From: Judith Ward
Sent: 08 August 2018 12:10
To: Emily Shaw
Subject: 18/00168/DISC Site D and E Graven hill

Judith Ward
Landscape Planning Officer
Cherwell District & South Northants Councils

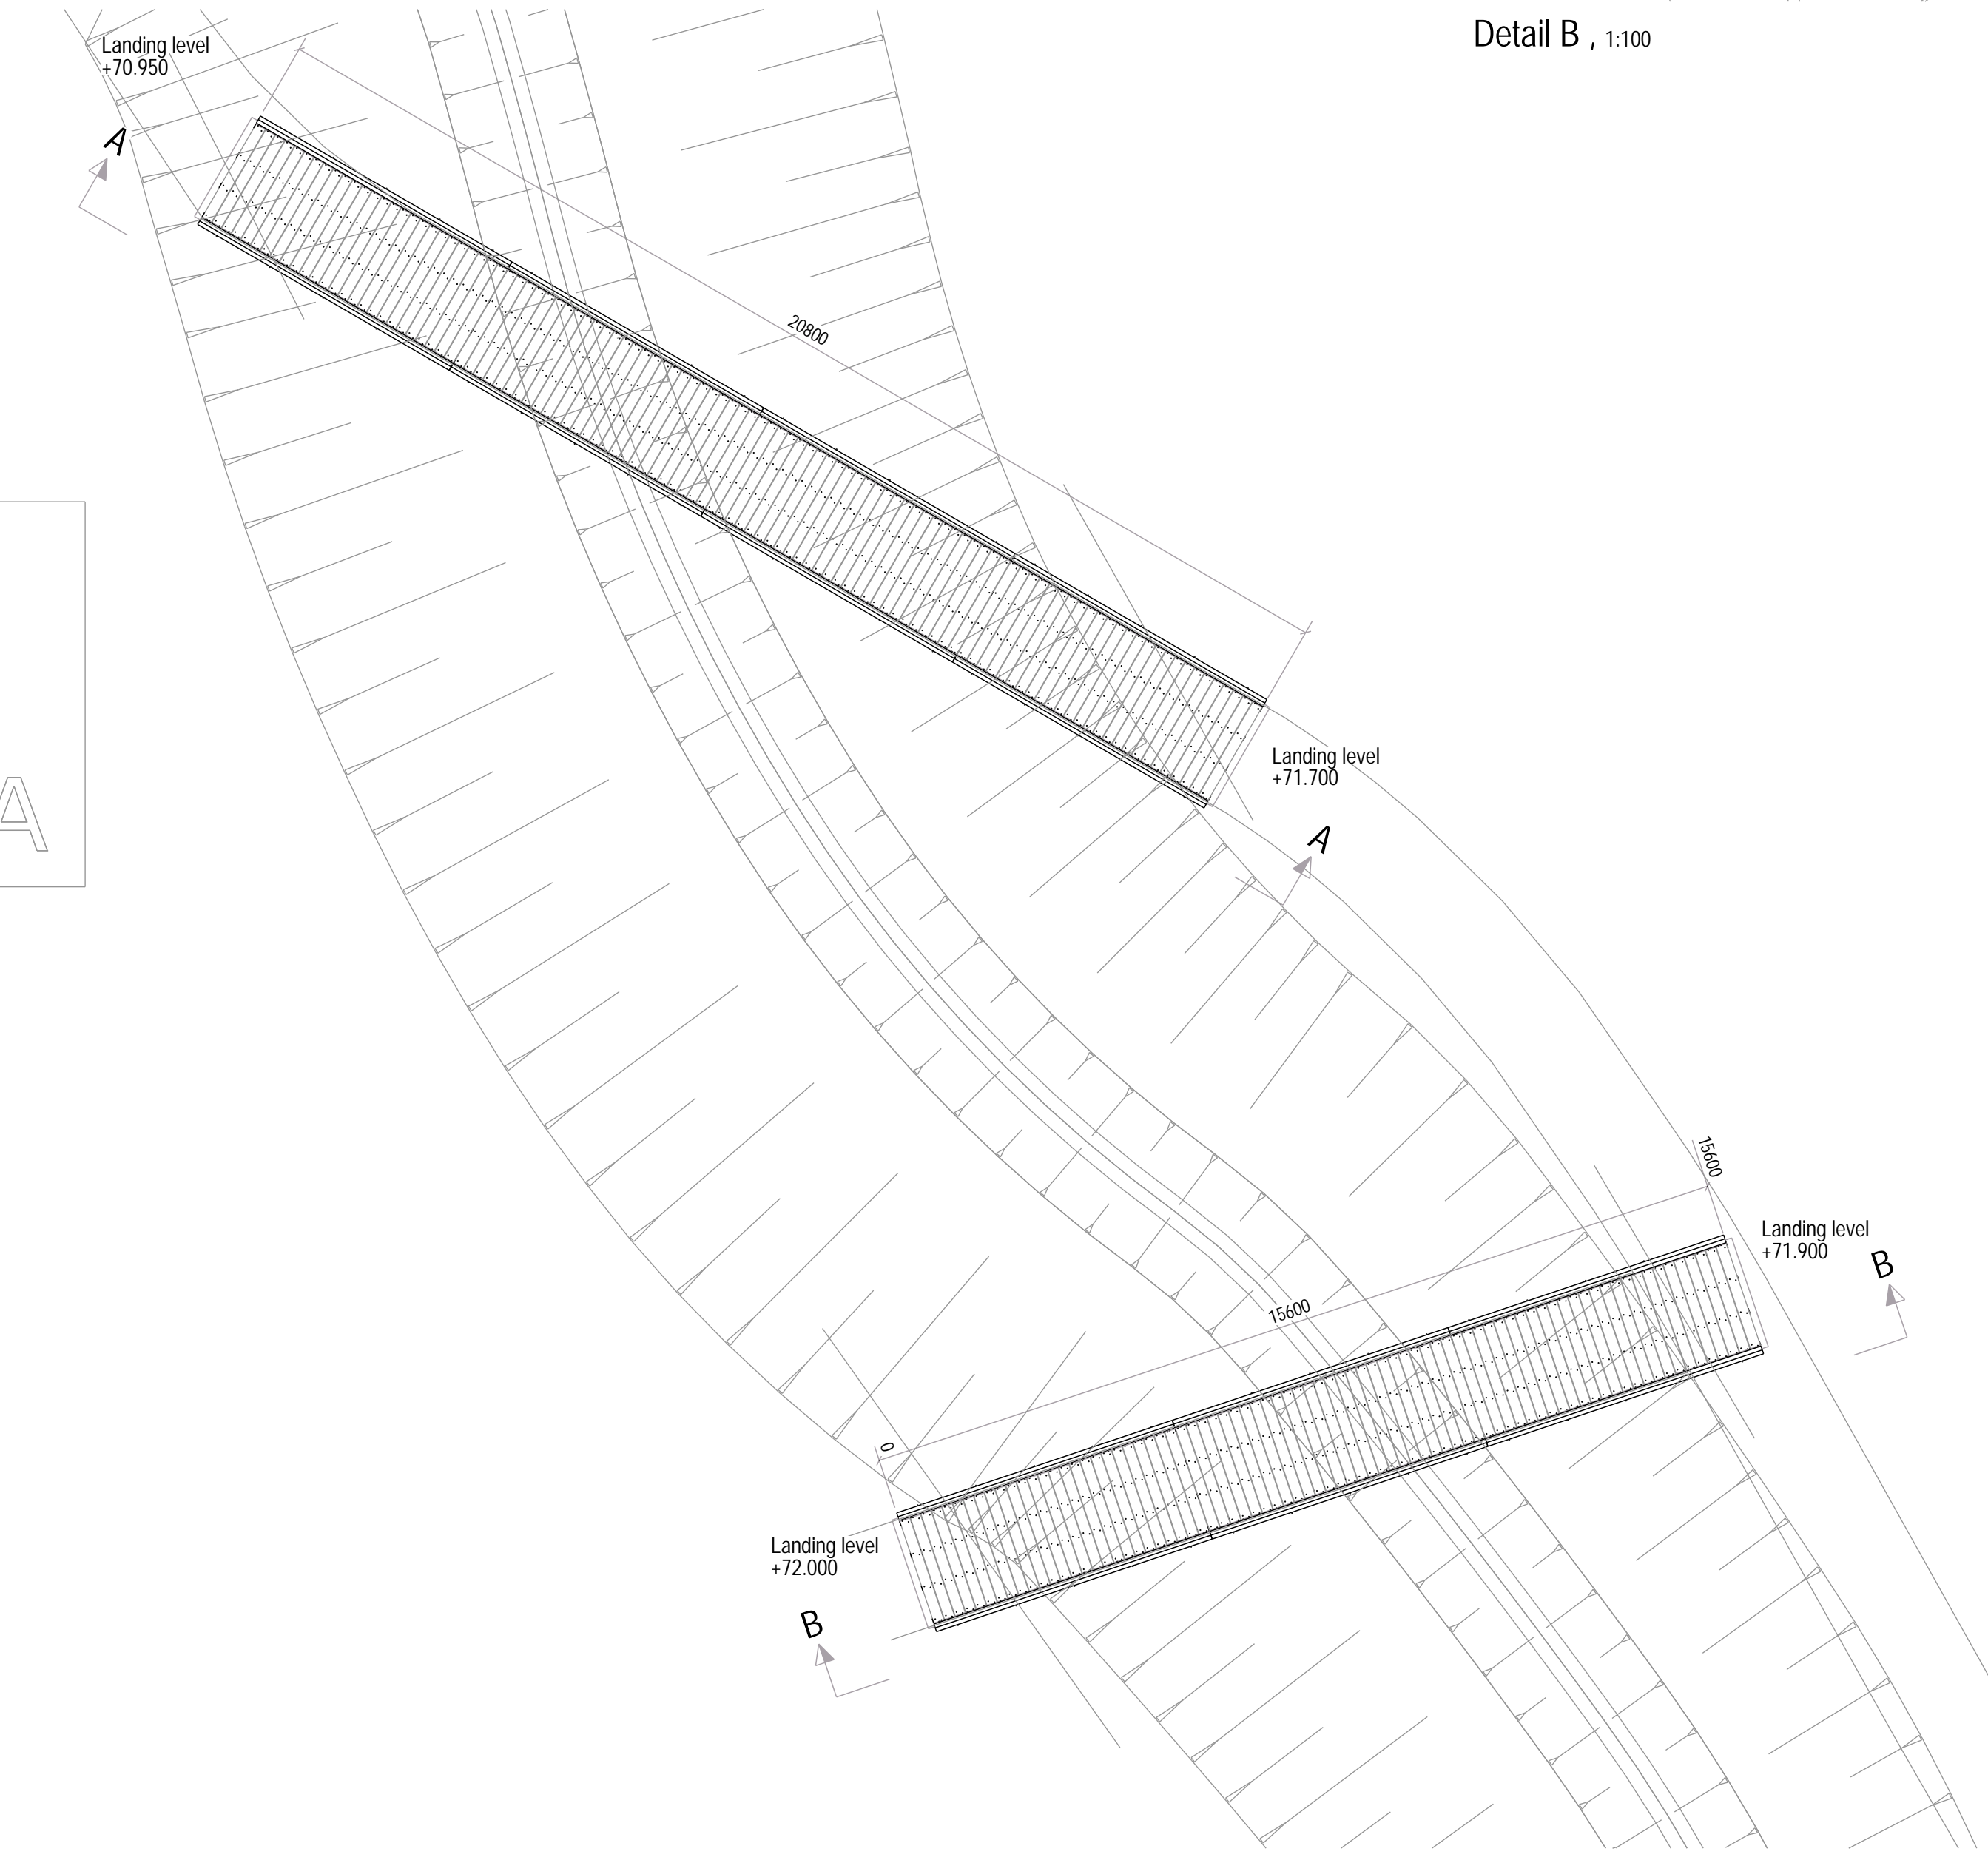
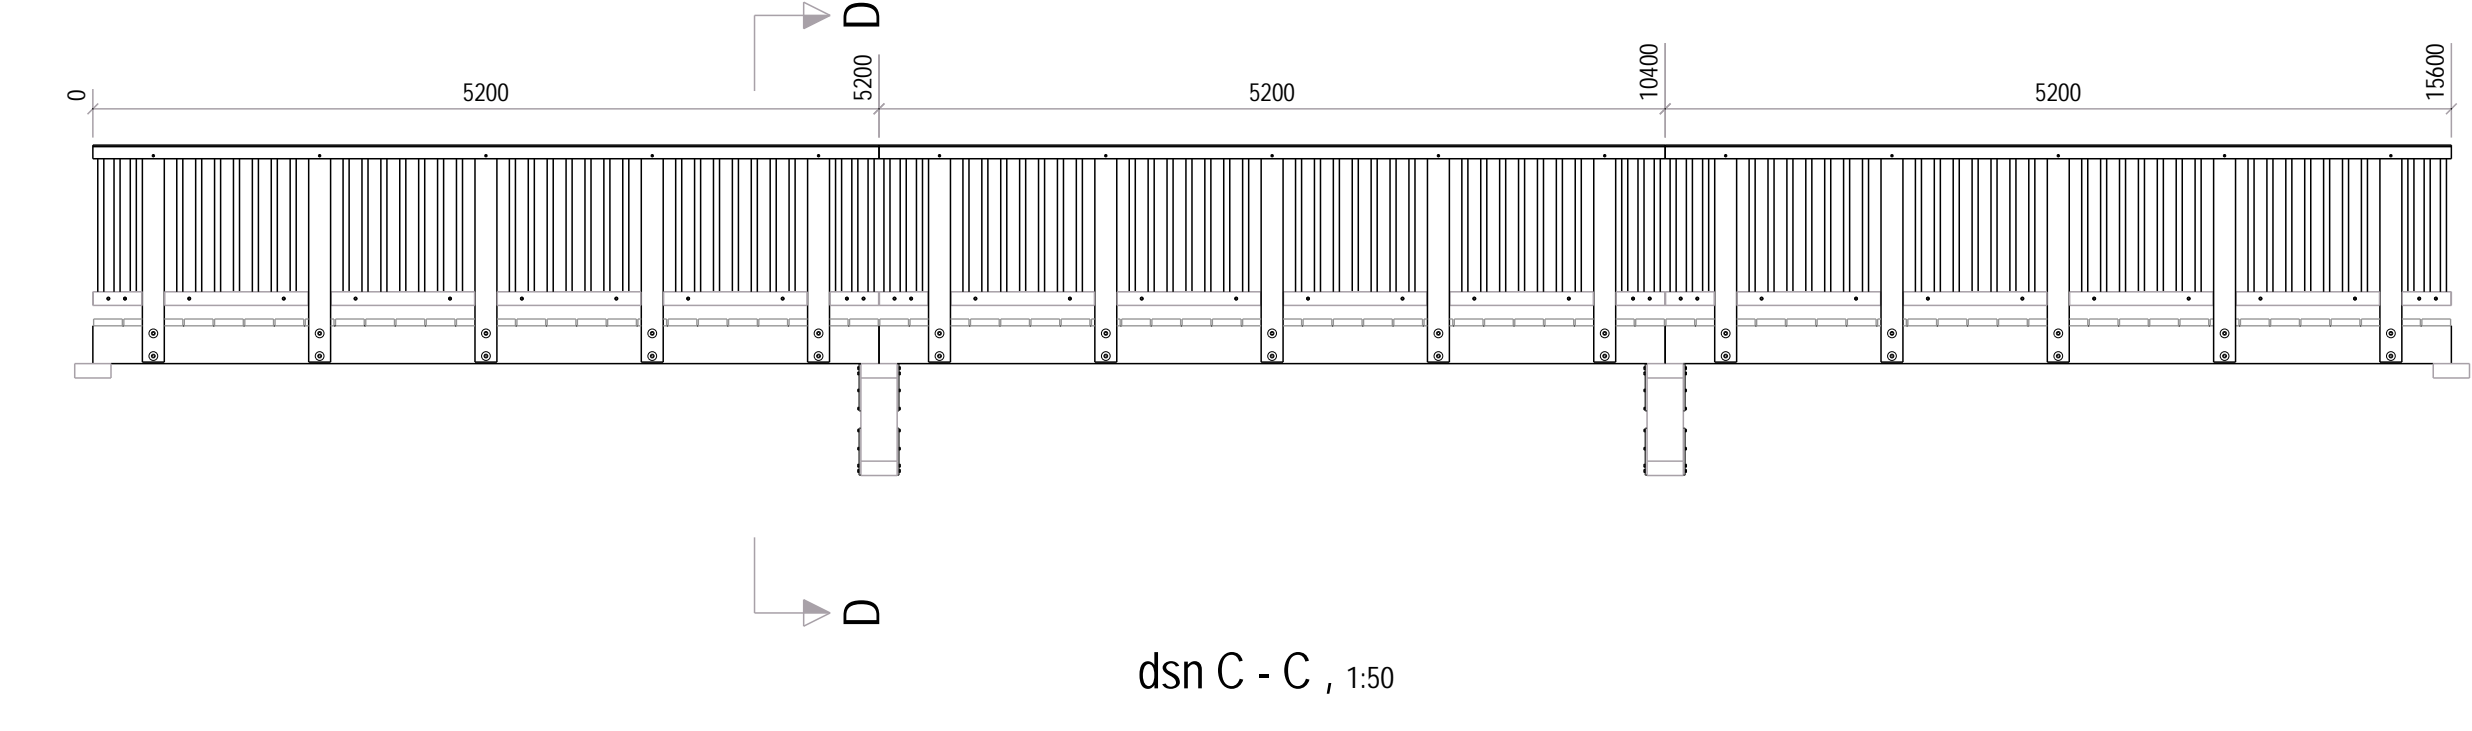
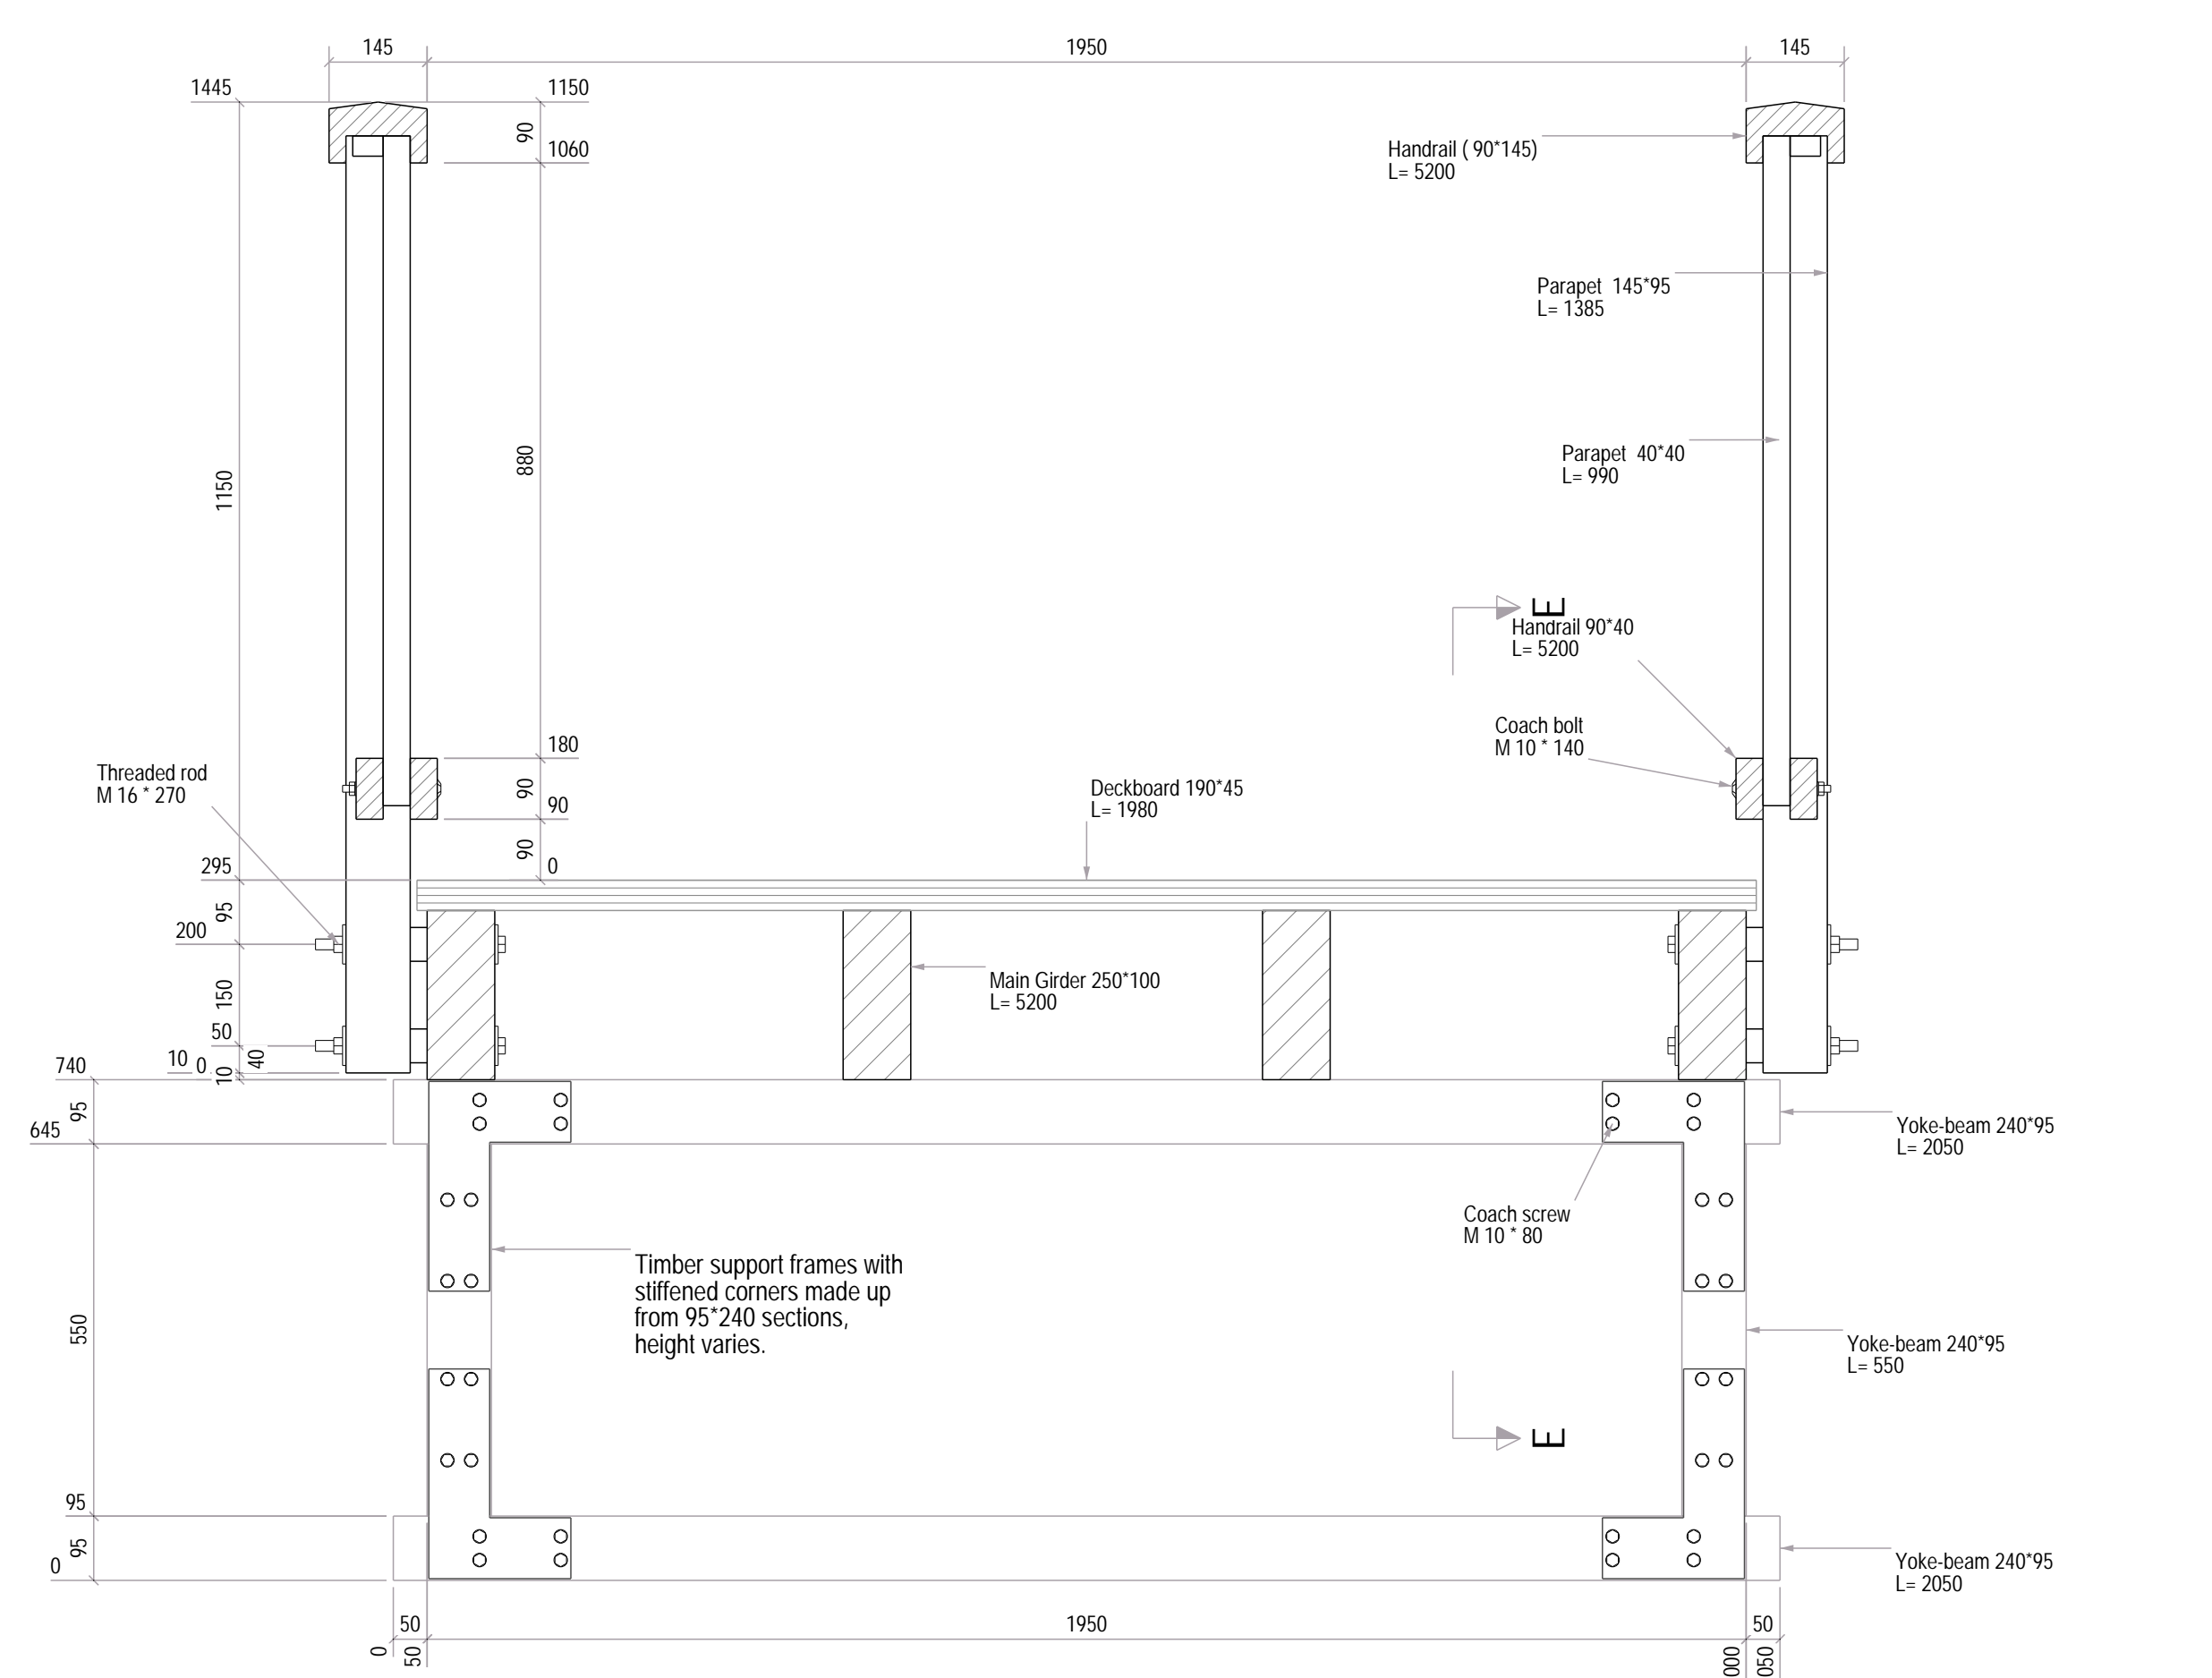
Condition 9. The timber bridge and walkways are acceptable.
